**NORTH
NORFOLK
DISTRICT
COUNCIL**

Norfolk Boreas Offshore Wind Farm

REPRESENTATIONS FOLLOWING EXQ2 RESPONSES SUBMITTED AT DEADLINE 4

DEADLINE 6 – 05 MARCH 2020

Appendix F - COLBY ROAD (CHURCH ROAD), NORTH OF BANNINGHAM - SITE PLAN AND PHOTOGRAPHS

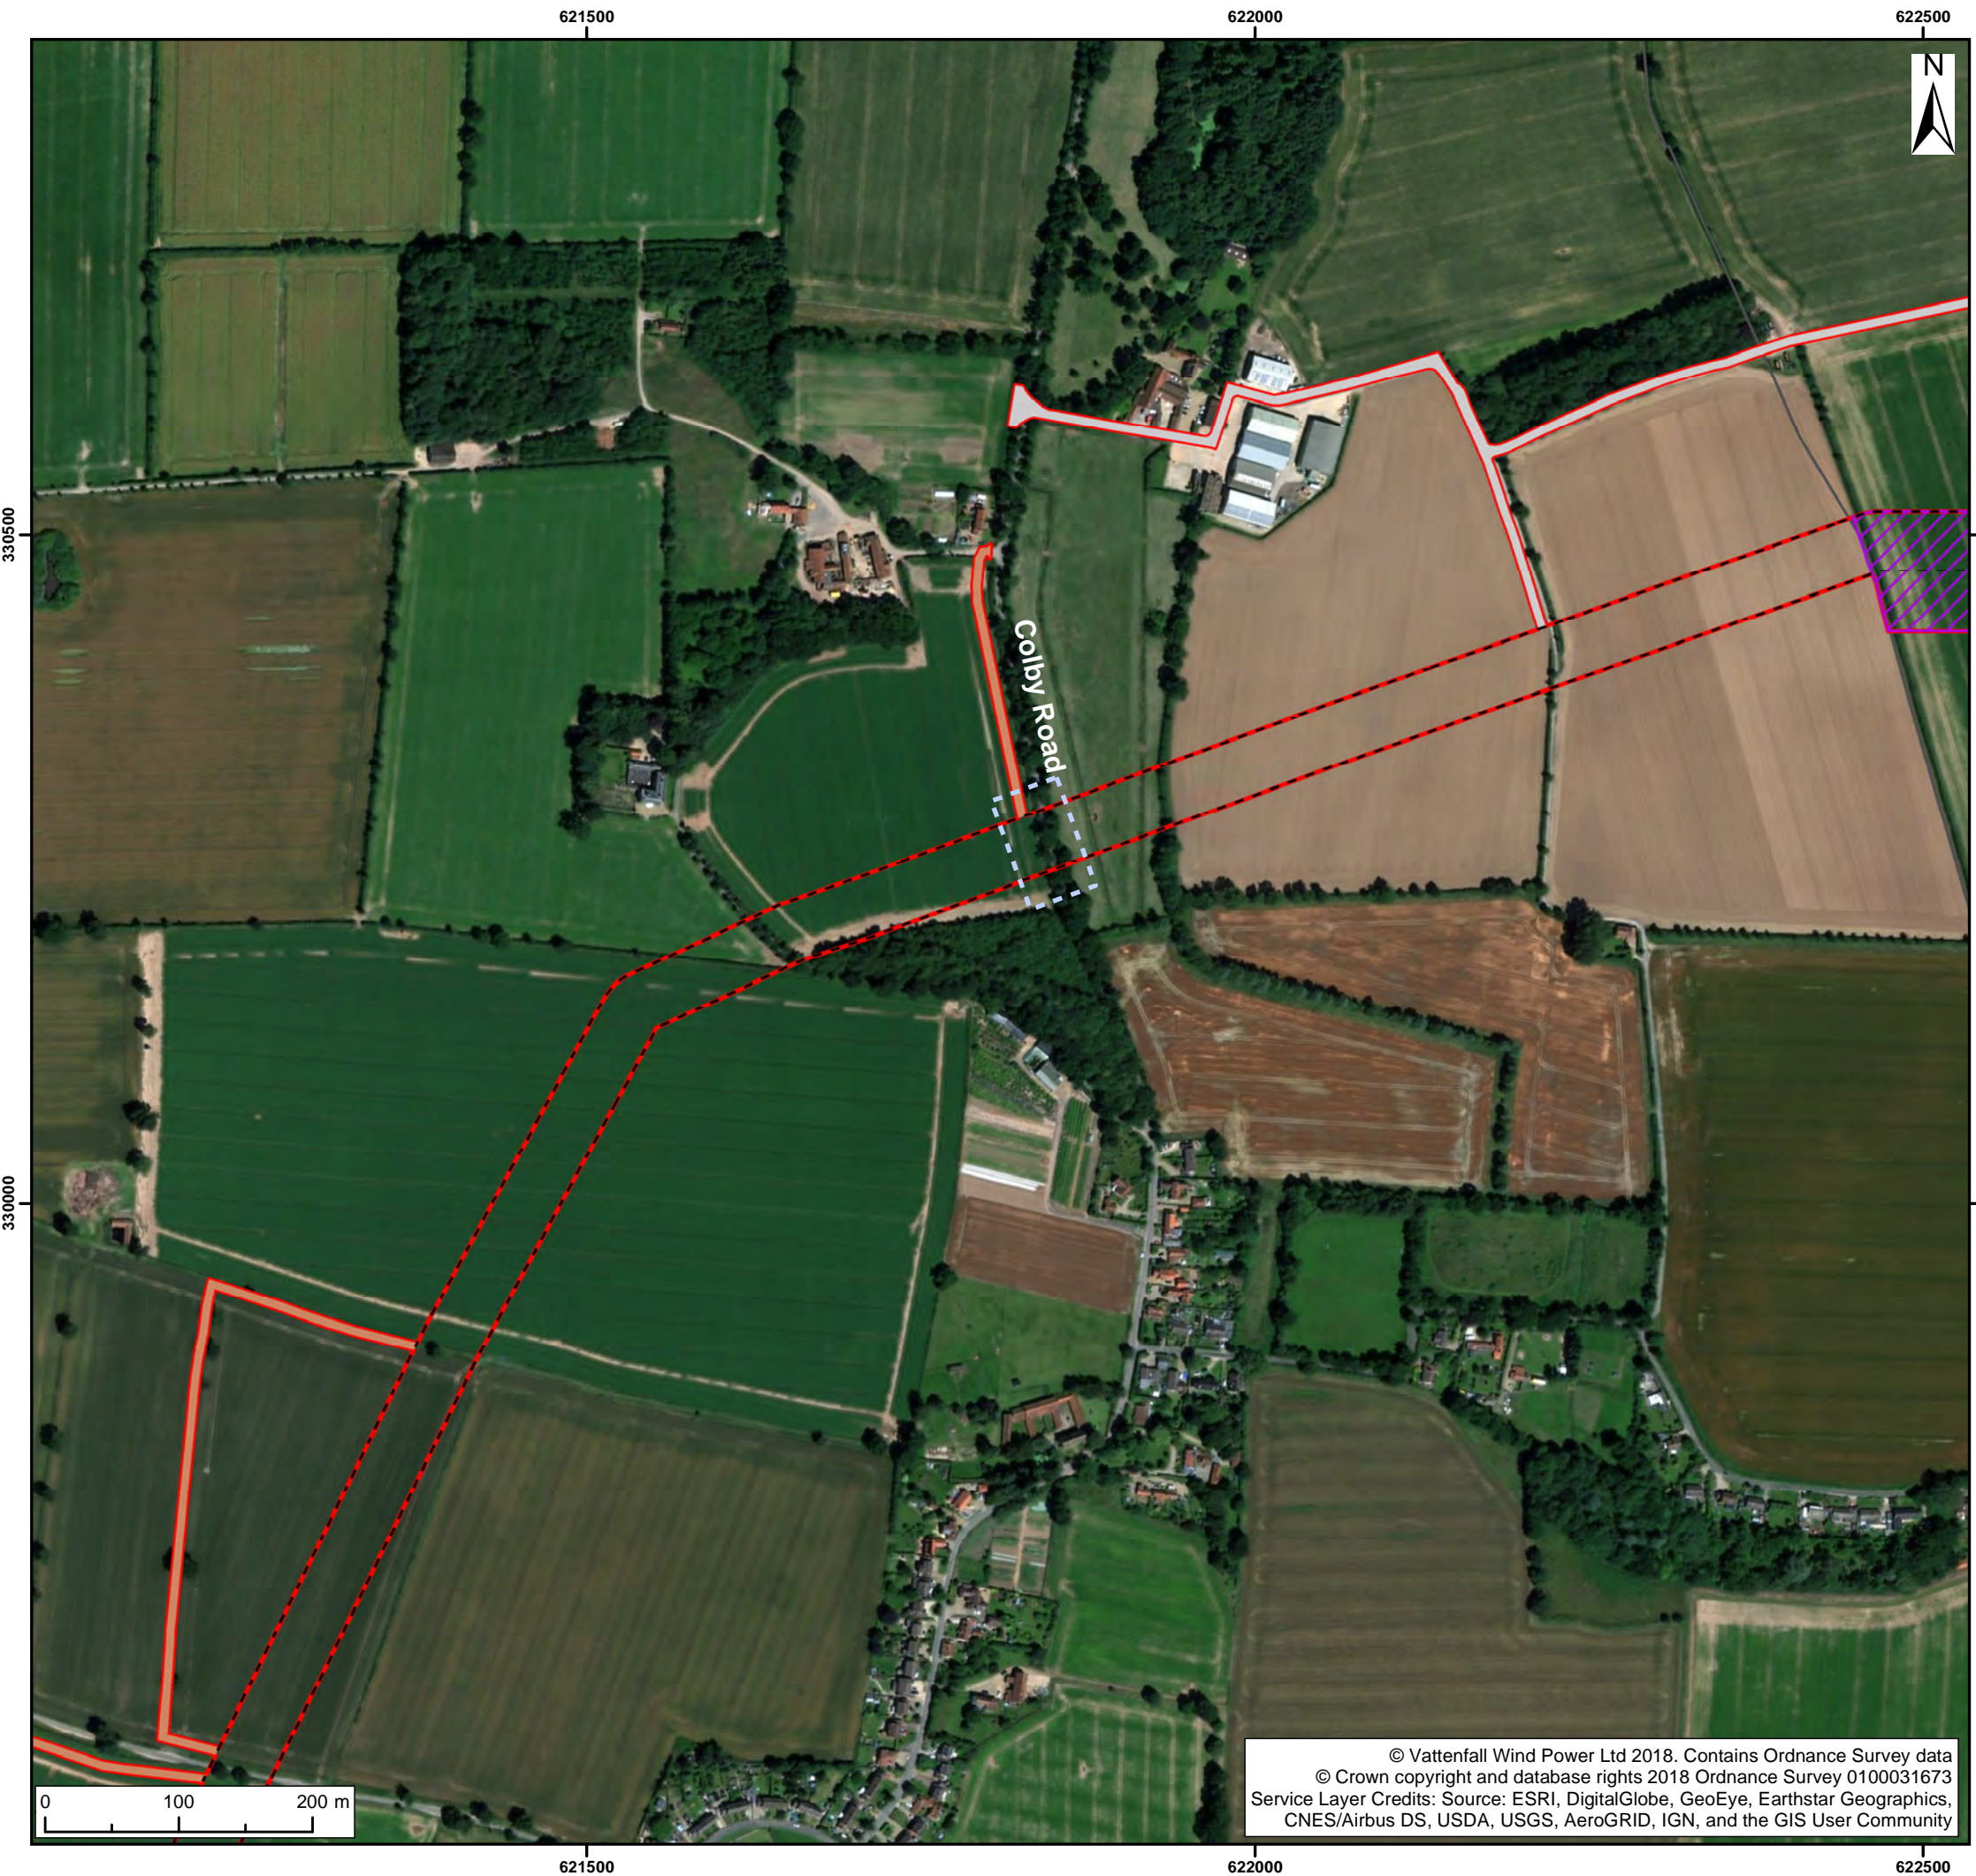
2.14. NNDC set out its position at Deadline 5 with regard to the pros and cons of a trenchless crossing at Church Lane, Colby.

2.15. NNDC have noted a series of errors within its submission with reference incorrectly given to Colby Road, Banningham. This of course should have read Church Road, Colby. This applies to NNDC's response to Q2.5.0.2, Q2.9.3.1, Q2.12.0.3 (various) and in the title of Appendix B.

2.16. In respect of NNDC's proposed alternative solution to enable trenchless crossing under Church Road, Colby submitted at Deadline 5, following a teleconference with the applicant on 04 March 2020, NNDC understands that the applicant is considering the option presented and will provide further comment in due course.

2.17. Whilst the updated position of the applicant is awaited, NNDC would recommend that the ExA visit the Church Road, Colby area as part of the Accompanied Site Visit on 19 March 2020. This will allow all parties to see the site for themselves and to consider the alternative option(s) design to avoid unreplaceable tree loss over the easement area of the cable route.
